# Charlotte Department of Transportation

## Memorandum

**Subject:** Rezoning Petition 08-064: Located on the west side of Frazier Avenue  
between West 5th Street and Martin Street

**PROPOSED  
REZONING PLAN**

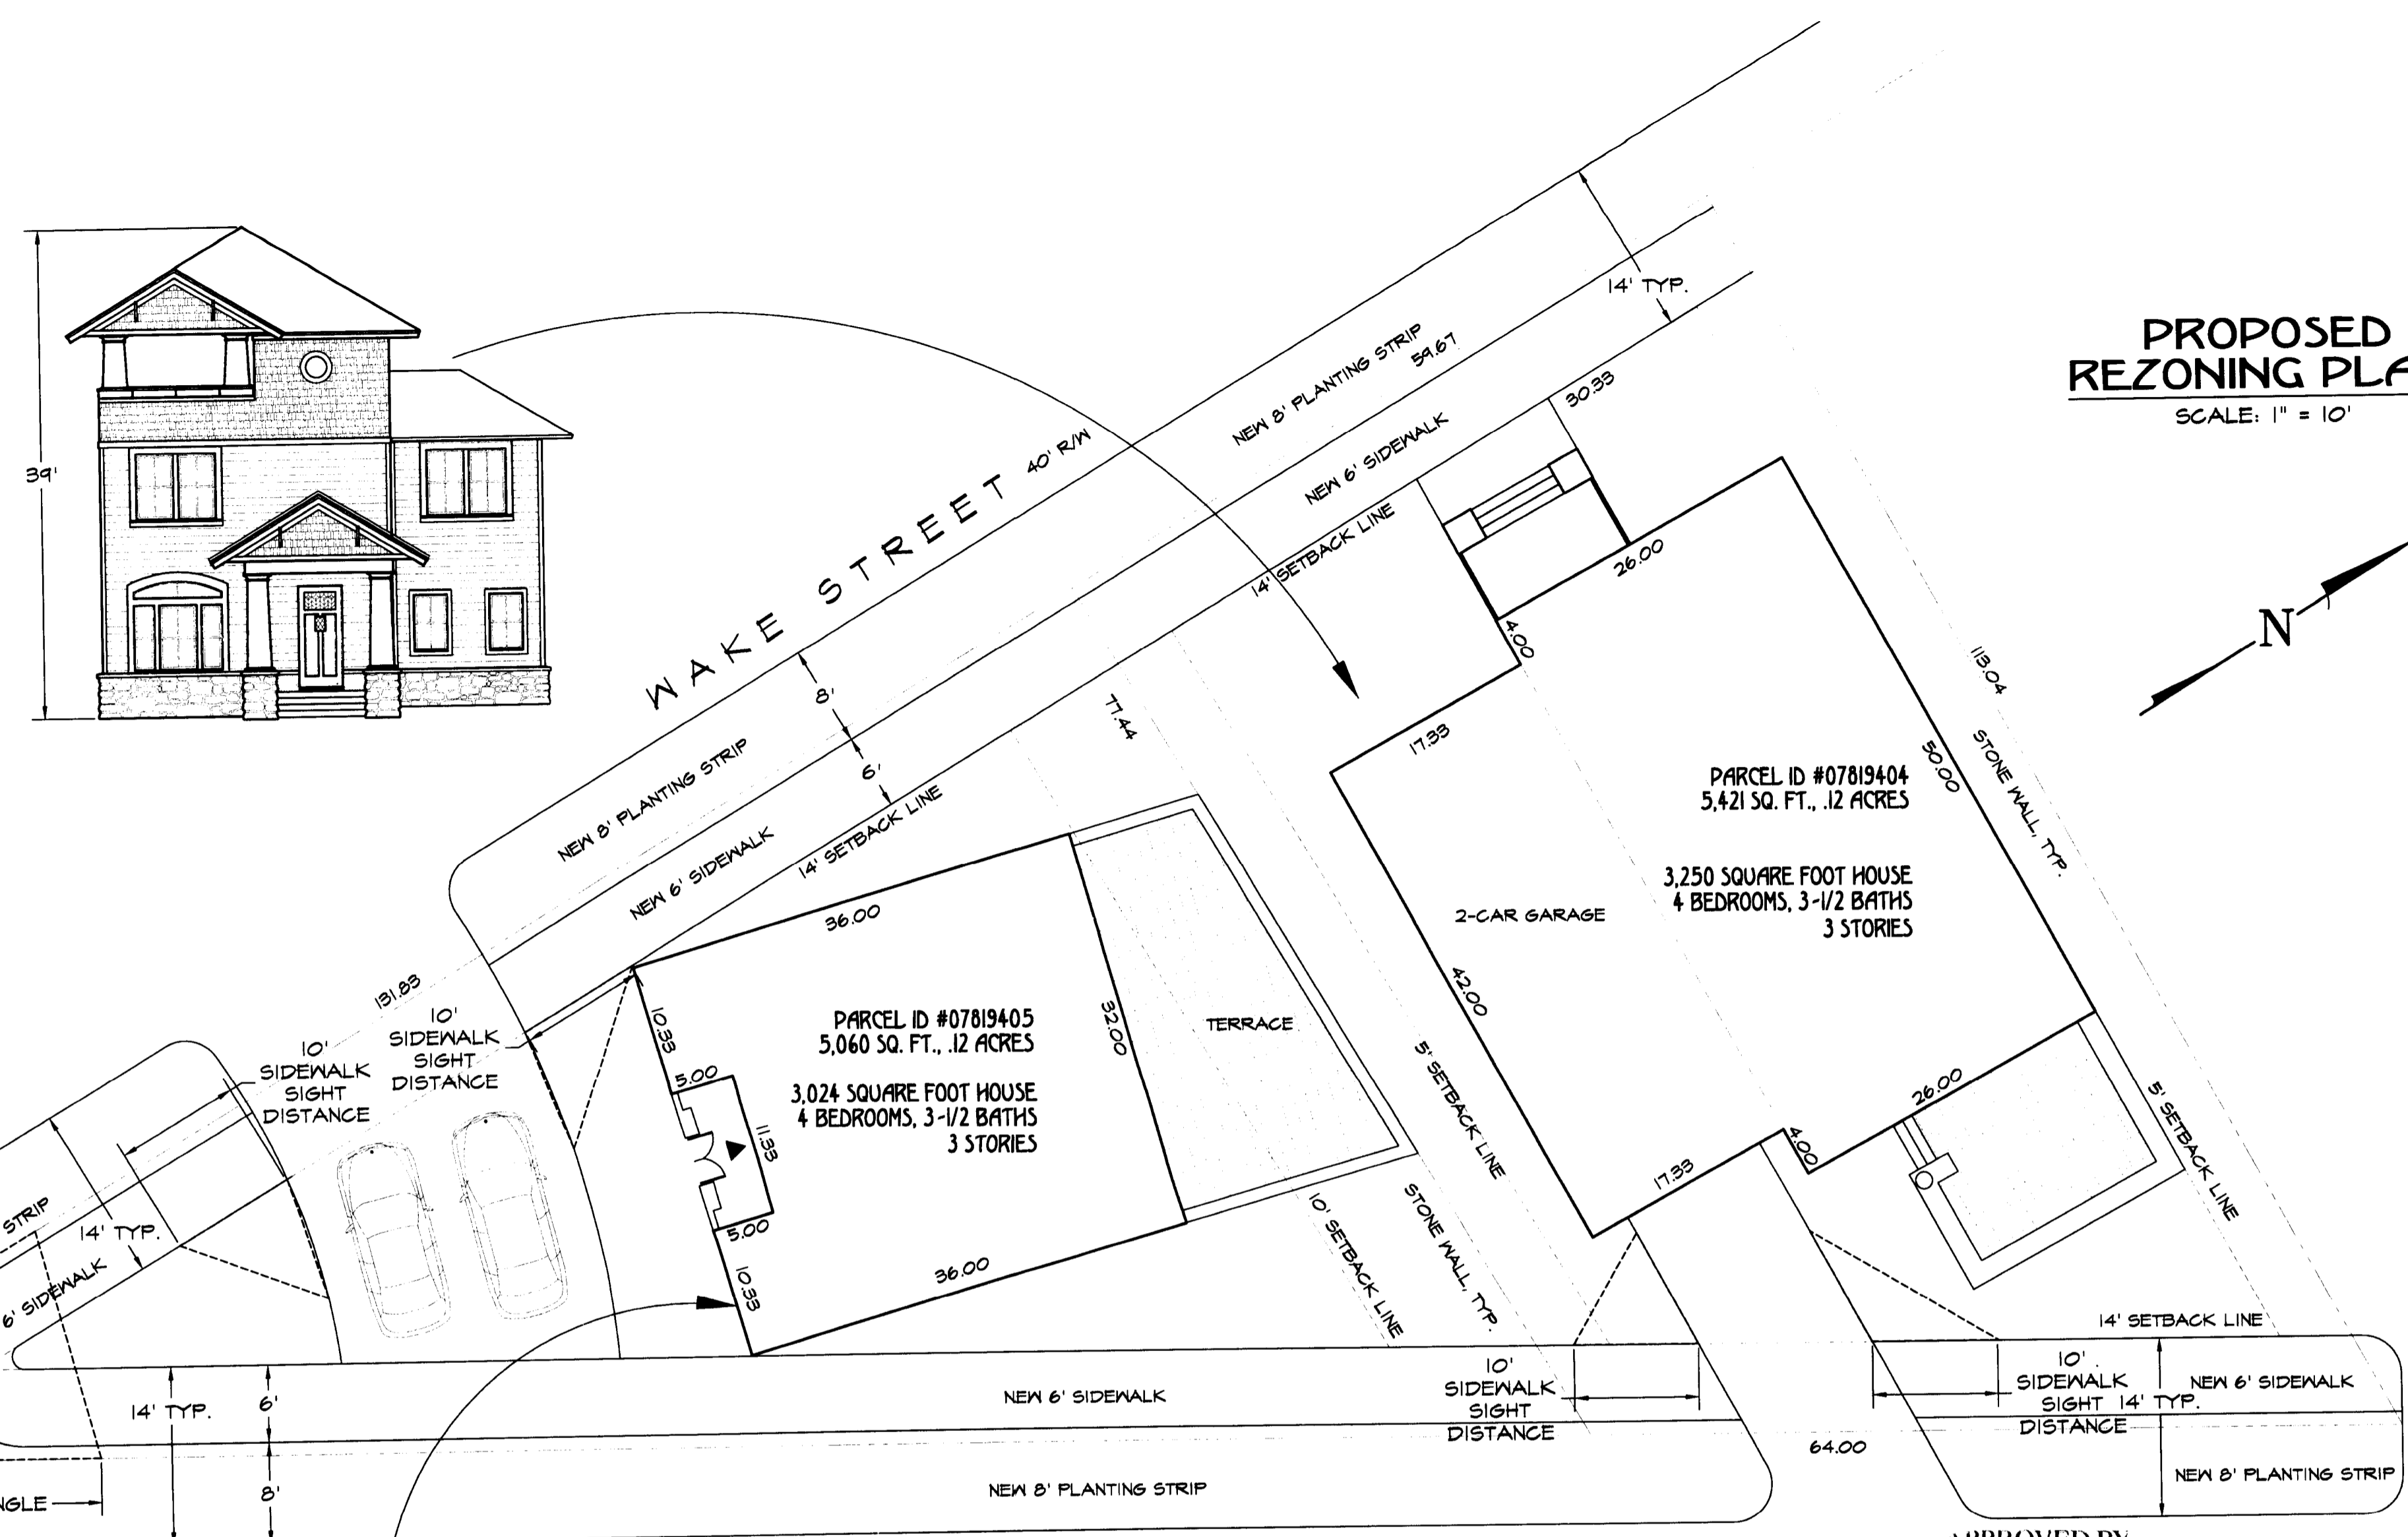
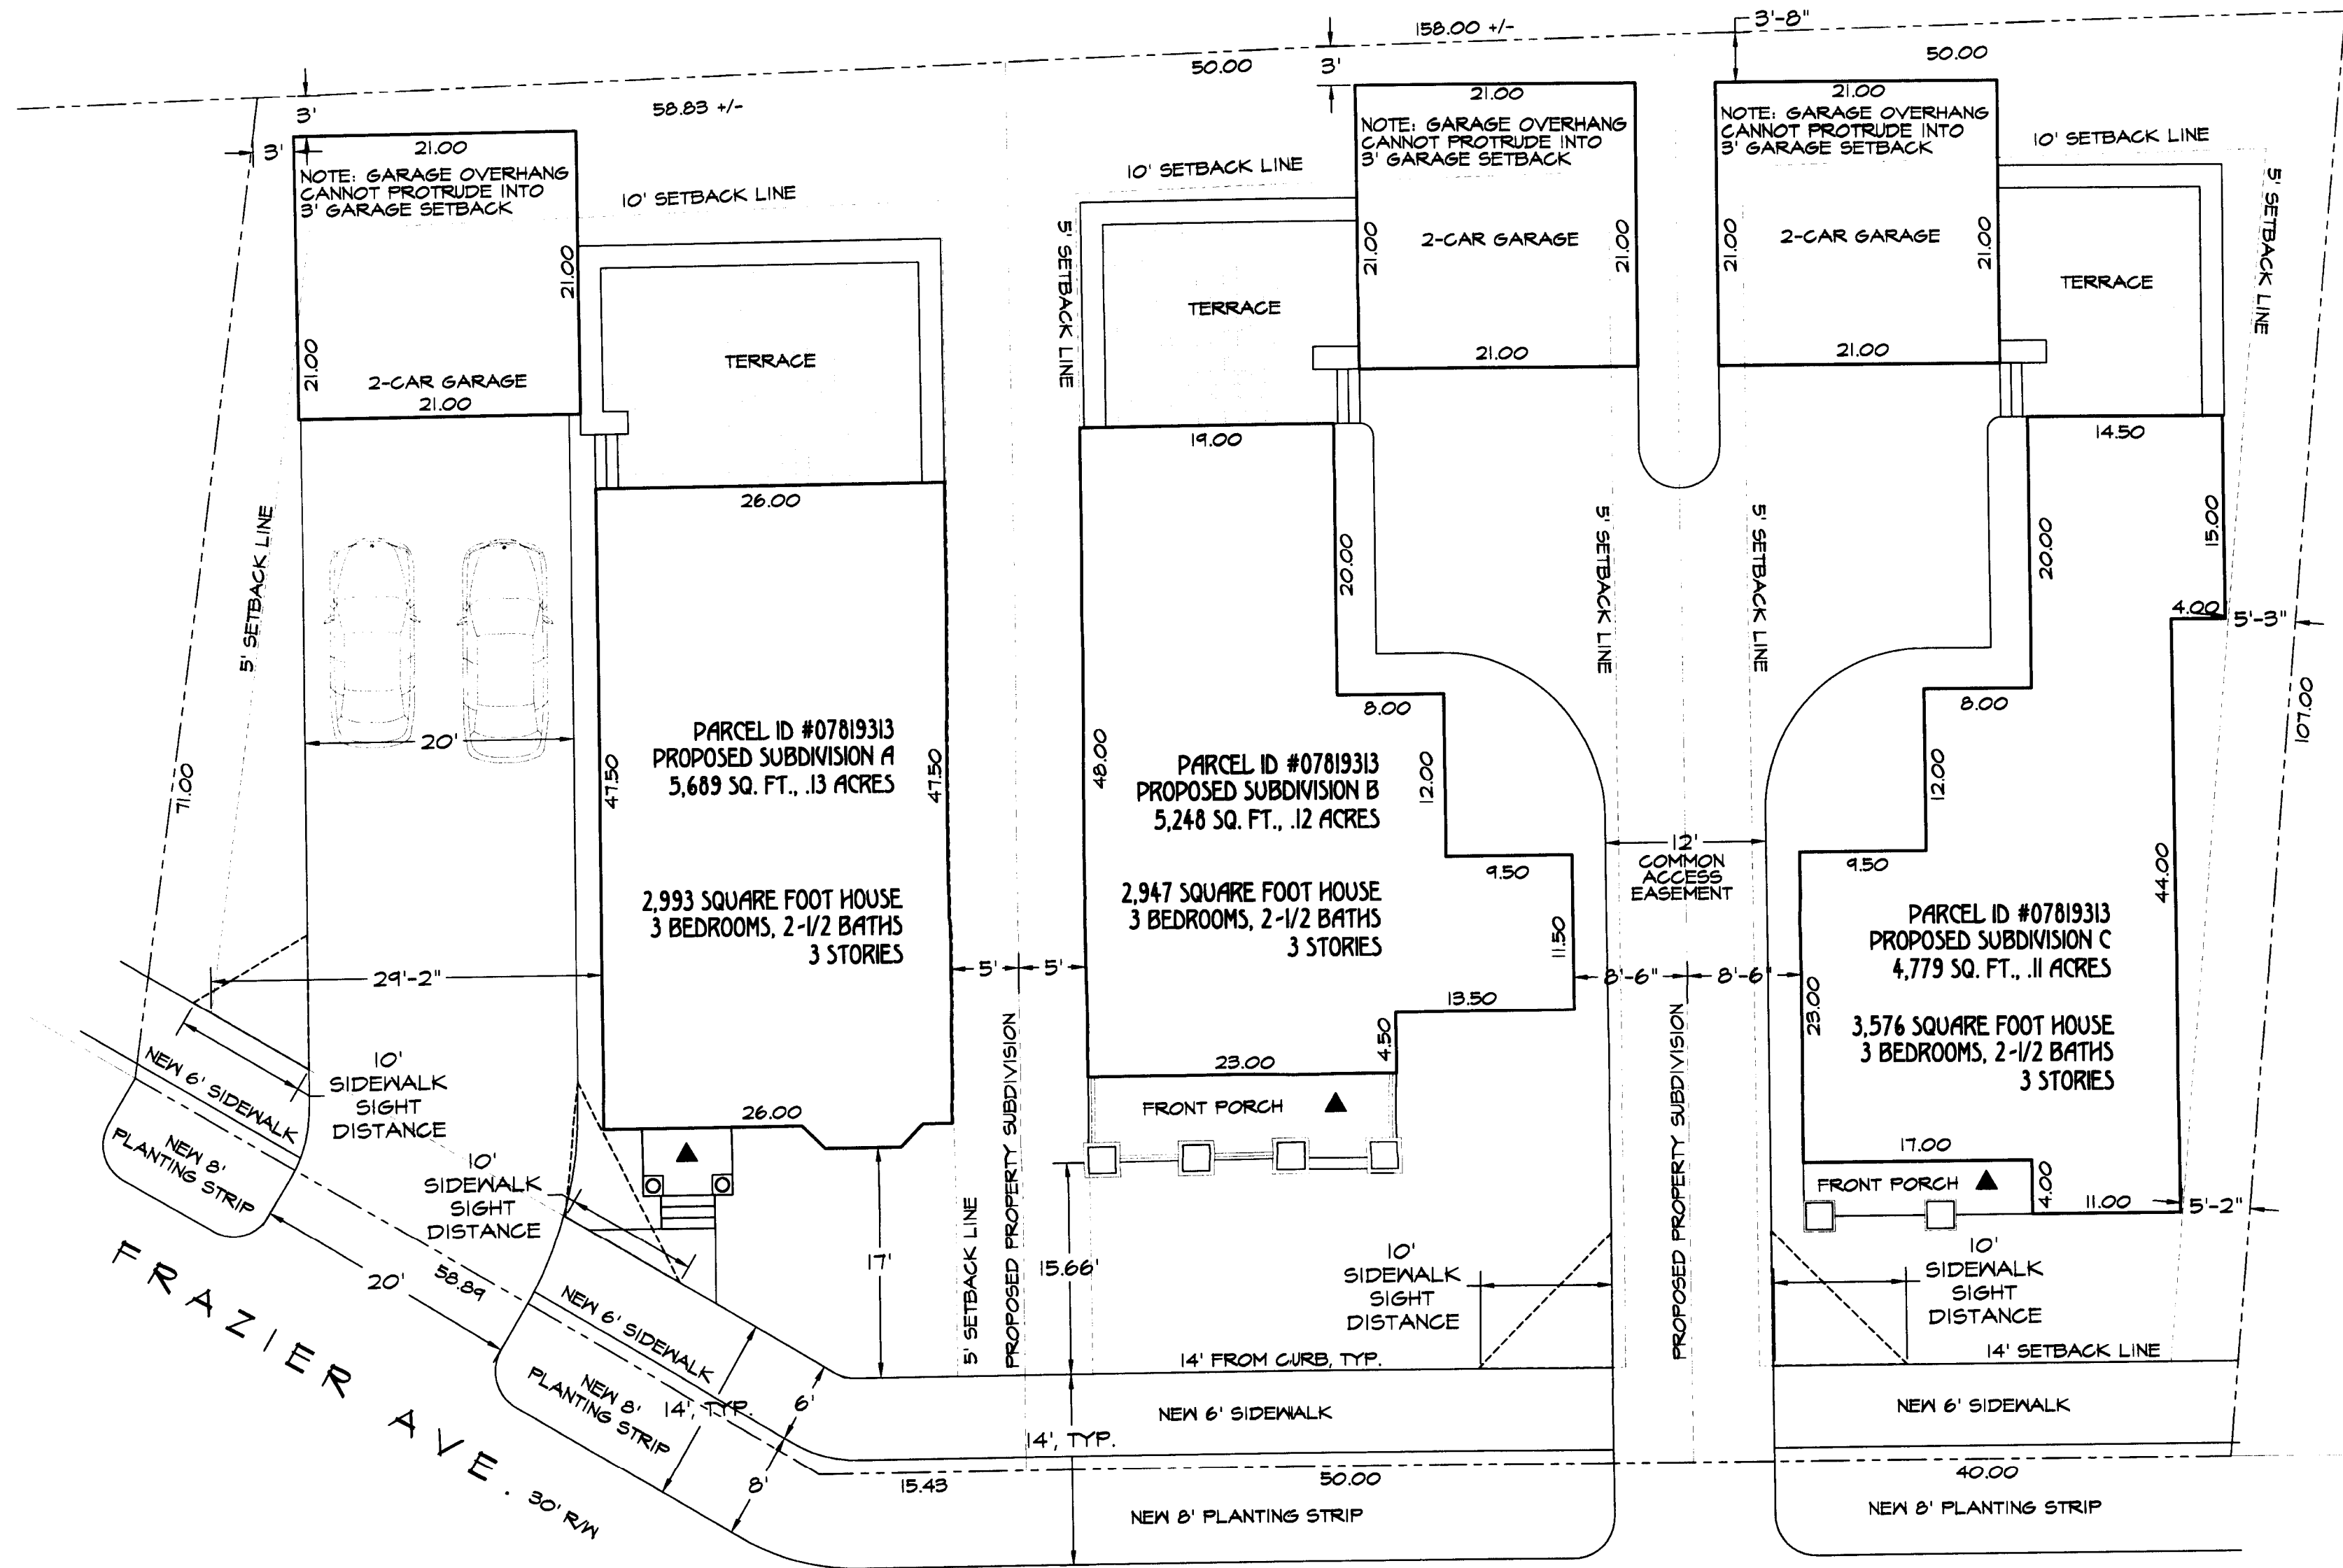
1. The existing sidewalks that are located at the back-of-curb along Wake Street and Frazier Avenue need to be replaced with 4' planting strips and 5' sidewalks to be in conformance with the existing character of the surrounding neighborhood, except where existing stone walls need to be preserved.
2. Normally, the existing sidewalk at the back-of-curb along West Fifth Street would warrant a request for replacement by an 8' planting strip and 6' sidewalk. However, there appears to be challenges in topography. The petitioner is requested to contact CDOT's Pedestrian

Program Manager (Vivian Coleman at 704.353.0481) to discuss alternative designs that still enhance the pedestrian realm while minimizing grading issues.

3. At least a 20-foot offset needs to exist between the back-of-sidewalk and the front of each garage. The 20-foot space is necessary to provide enough storage for a vehicle without blocking the public sidewalk.

4. The proposed pull-through driveway located on tax parcel #07819405 at the corner Frazier Avenue and Wake Street needs to be removed from the plans. CDOT can only support one driveway for this residential unit.

5. The City's *Driveway Regulations* require driveways to be perpendicular (90°) to the street and set back. At least two of the driveways are at angles between 60-70° and cannot be approved.

6. Stone walls are shown along the street frontages of several of the units. The installation of fences and walls along or adjacent to the street right-of-way, require a permit issued by the CDOT. Walls will be restricted or prohibited within sight triangles at intersections and at driveway locations. Clear visibility (no obstructions) within these triangles must be maintained in a vertical clearance of 30-72" as measured from the ground surface. These items cannot be located within the right-of-way. Please provide a detail of the stone walls on a revised site plan.

7. A 35-foot by 35-foot sight distance triangle needs to be provided at the intersections of Frazer Avenue/Wake Street and Frazer Avenue/ West 5<sup>th</sup> Street. Two 10'x10' pedestrian sight triangles are required for each driveway connection to meet minimum requirements. One leg of the triangle is measured along the driveway, and the other leg is measured along the back of the sidewalk or right-of-way, which ever is the greater distance from the face-of-curb. All proposed structures, trees, berms, walls, fences, and/or identification signs must not interfere with the sight triangles at the driveway connection. Such items need to be identified on the site plan.

- Dimension width of the existing and proposed driveways.
- Indicate the locations and widths of all adjacent and opposing driveways.
- Indicate typical vehicle parking lengths in the proposed driveways so that they do not conflict with the sidewalk.
